**Re: U-Haul at 8200 Jefferson St. NE
Erosion and Sediment Control Plan – C17E146 – (SWQ-2025-00051)
Engineer’s Stamp Date: 2/4/26**

Based on the information in your submittal received on 2/4/26, , the ESC Plan is conditionally acceptable for inclusion in the SWPPP. Additionally, the EPA Notice of Intent (NOI) has been reviewed and signed by the city, and it is attached. Therefore, this project is approved for Building Permit with the following conditions.

NORTHWEST STORMWATER BASIN
 REQUIRED ESC SWQV VOLUME = 35,100 CF
 PROVIDED TEMP ESC SWQV VOLUME = 35,125
 PROVIDED TEMP SWQV ELEV = 5121.94
 (MIN 12" ABOVE REQUIRED VOLUME) TEMPORARY OVERFLOW ELEV = 5123.50

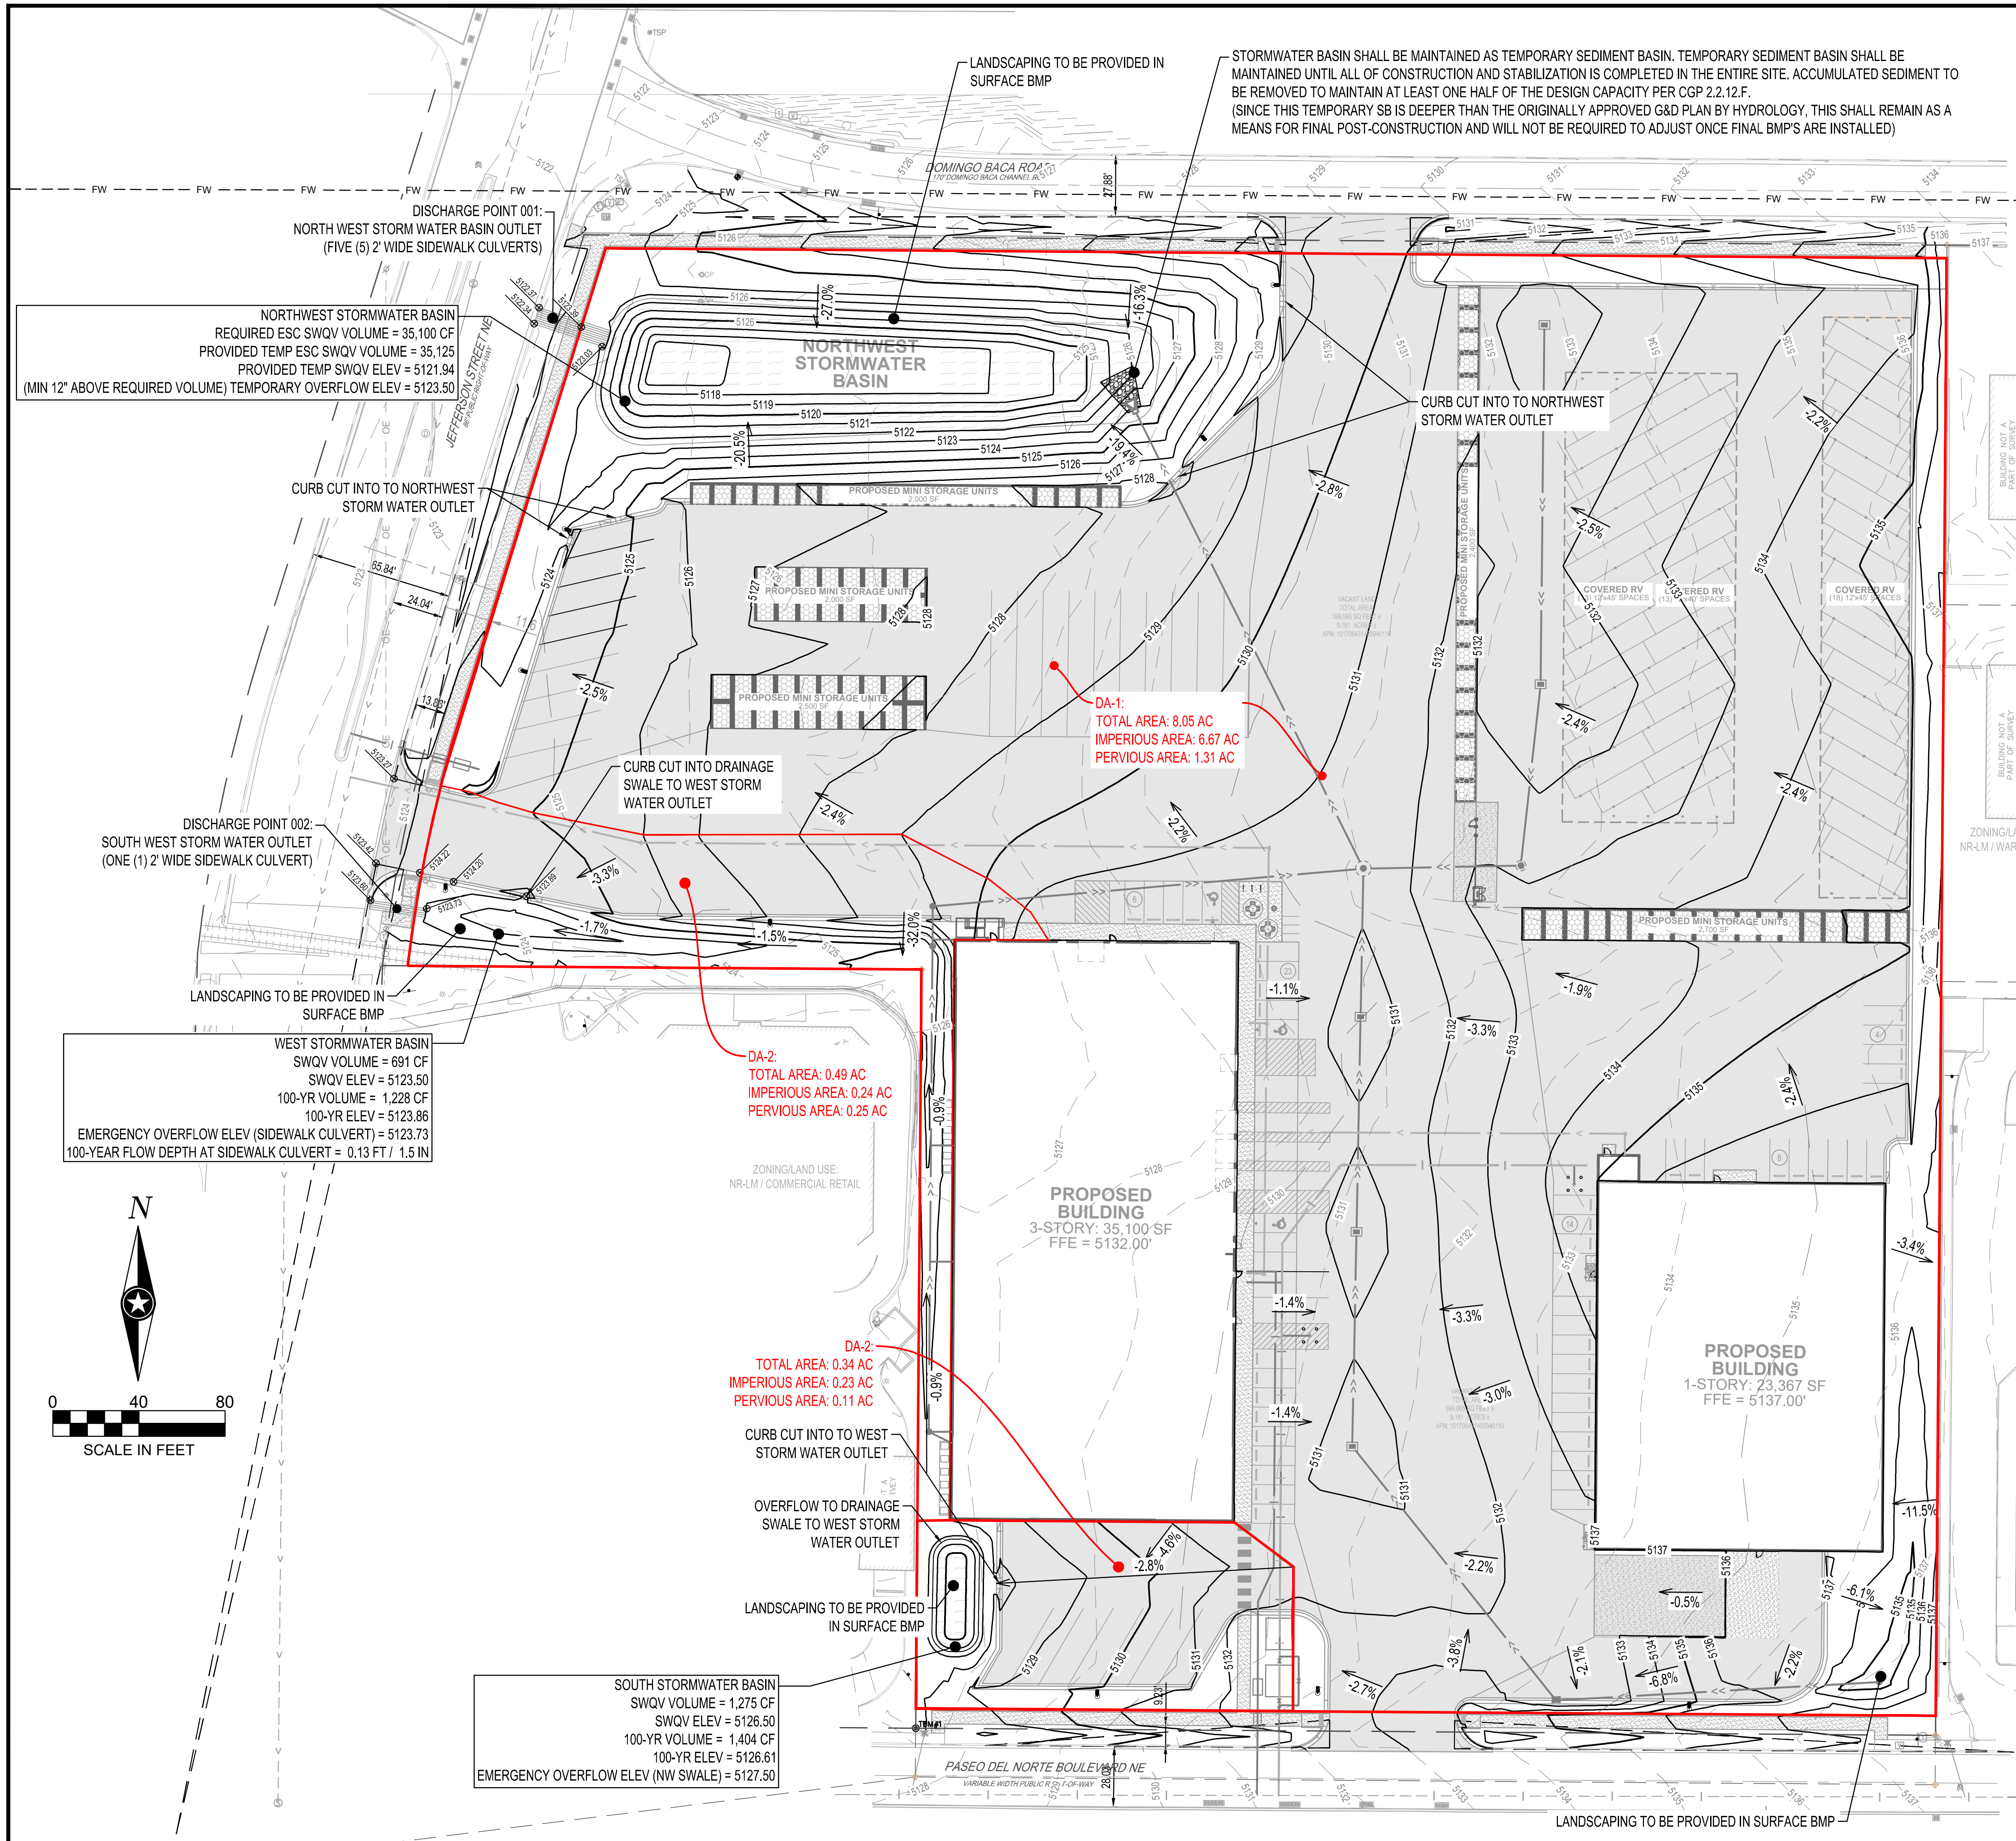
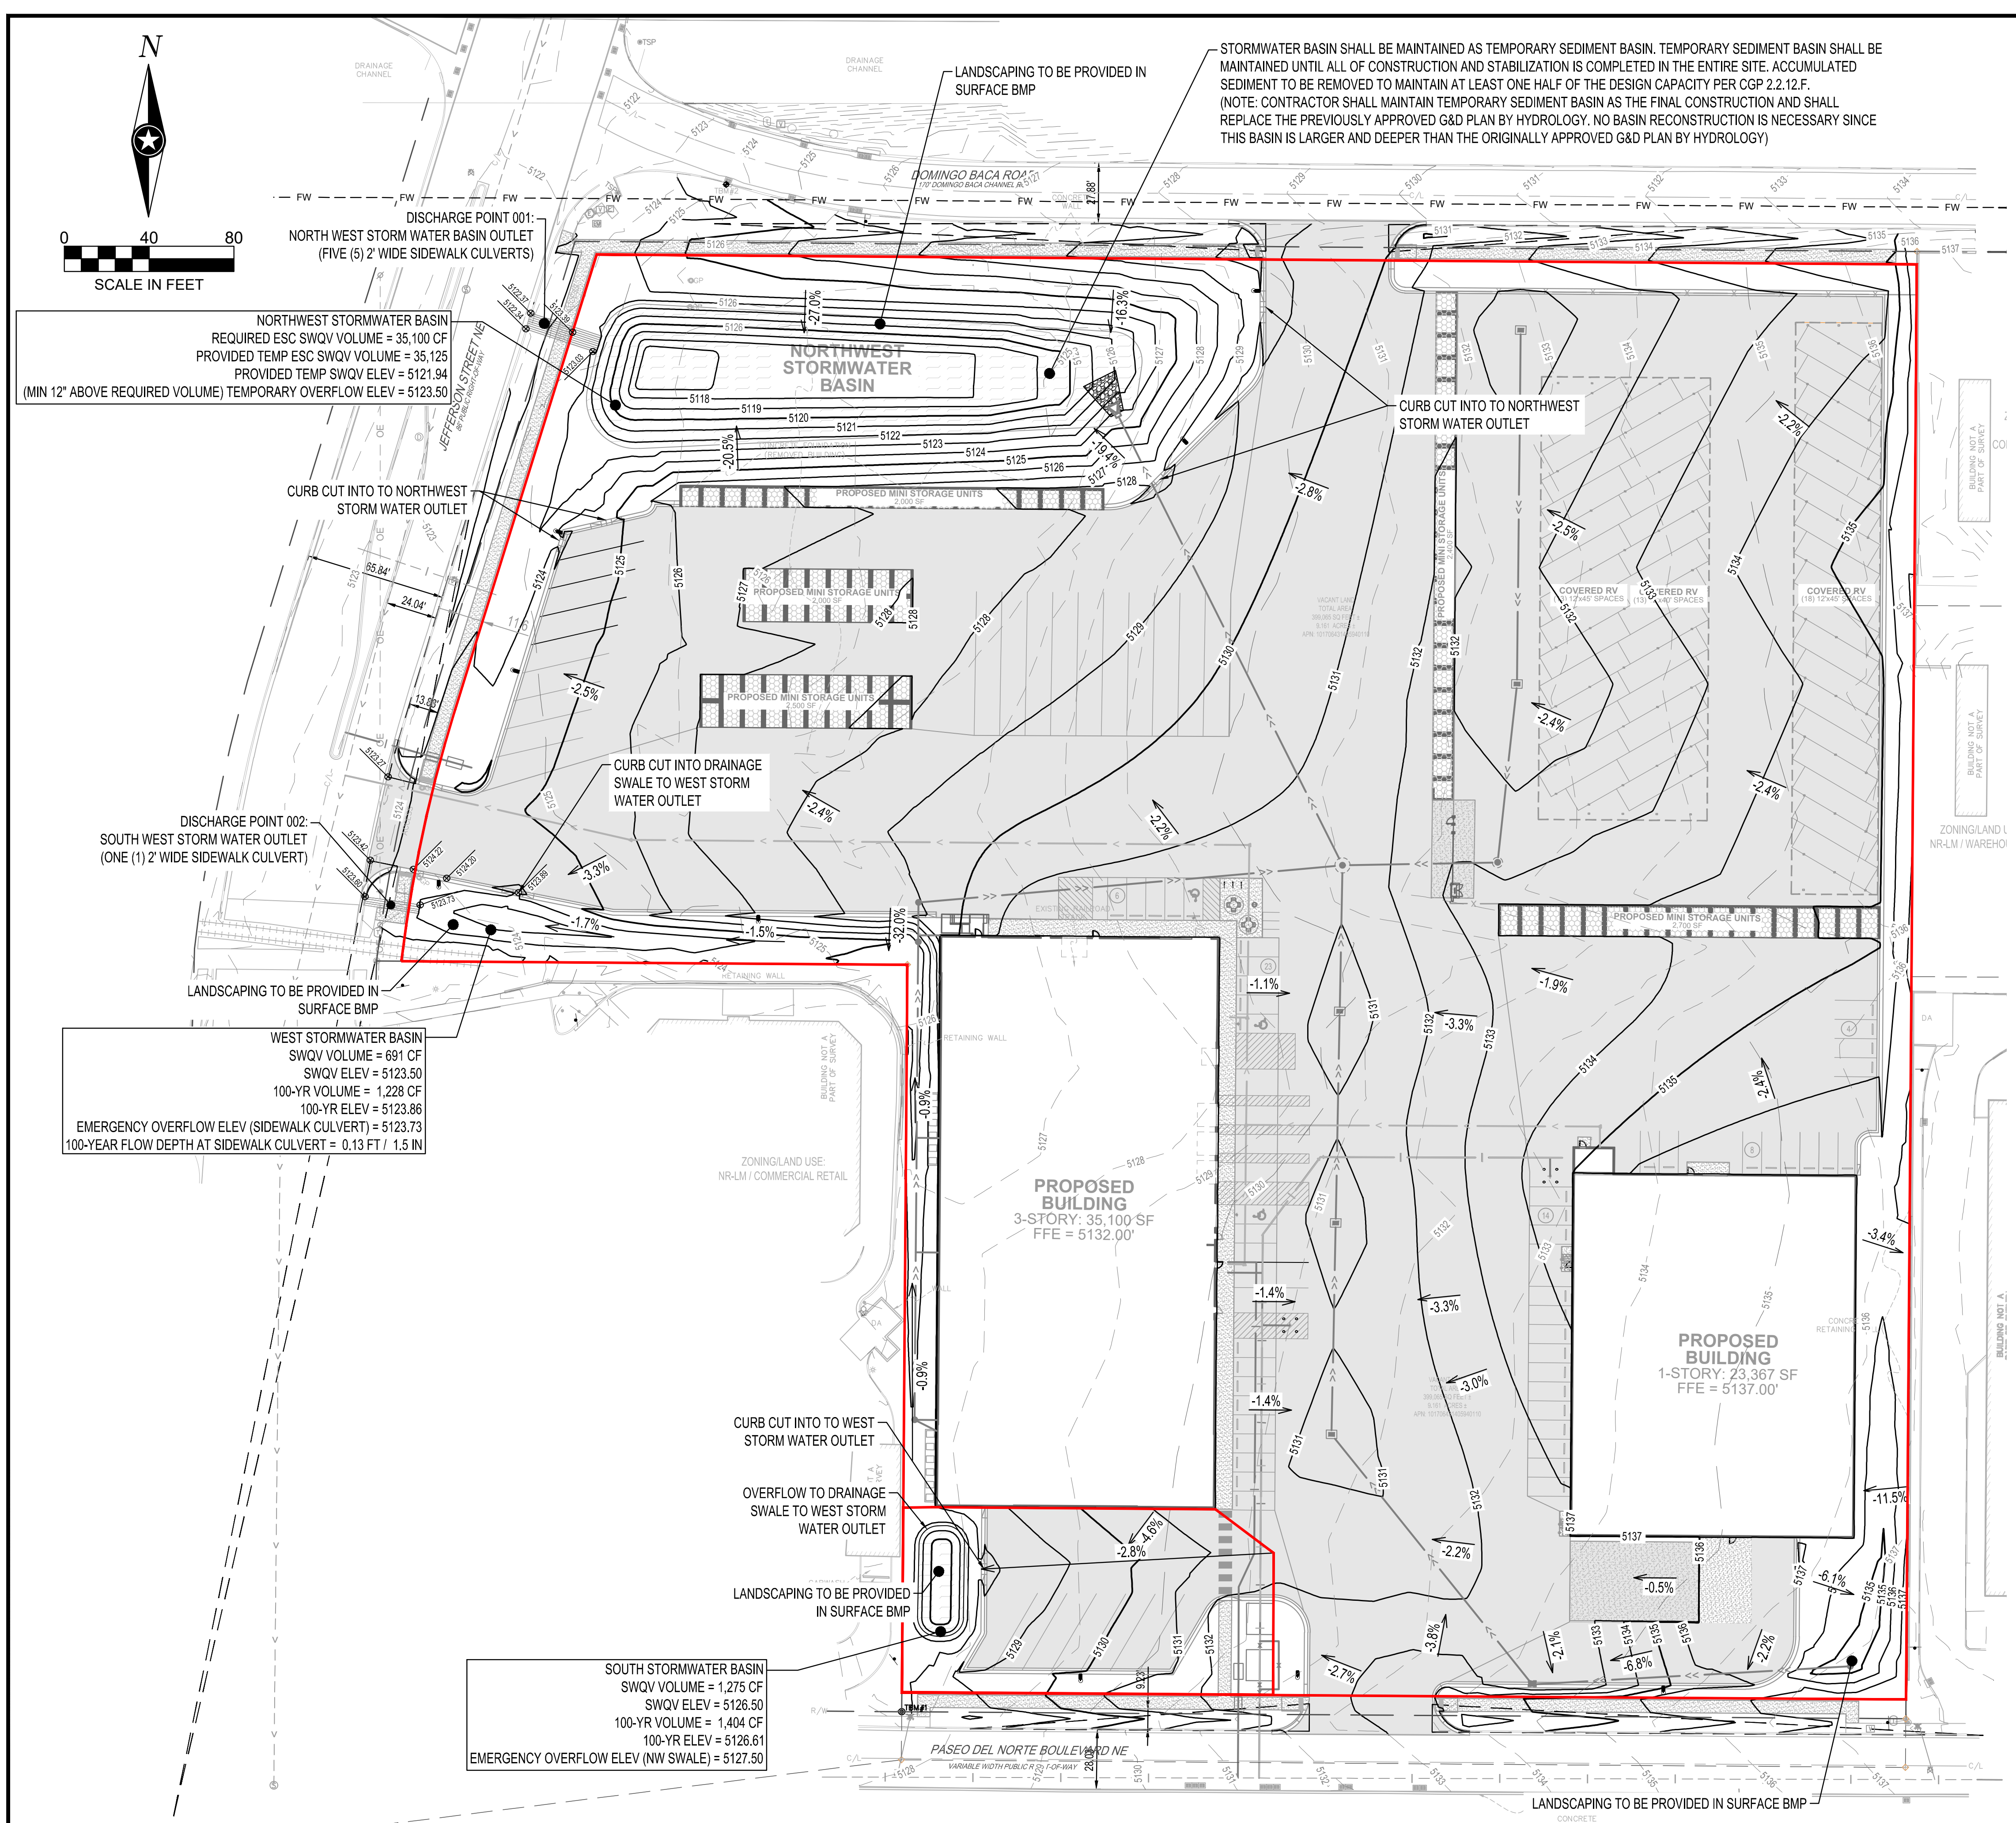
1. Inlets are missing, so the west storm drain cannot replace the DC until a plan showing the inlets is resubmitted to the SWQ Section and approved.
2. SWQ fees for the Work Order have not been paid. Neither Work Order Plans nor IIAs have been submitted to DRC. The pavement items on the infrastructure list aren’t shown on the ESC Plan. Demolition in the Public R/W isn’t allowed without a City Work Order and an NMDOT permit. The work order will not be approved until these items are resolved and an ESC Plan is resubmitted to and approved by the SWQ Section.
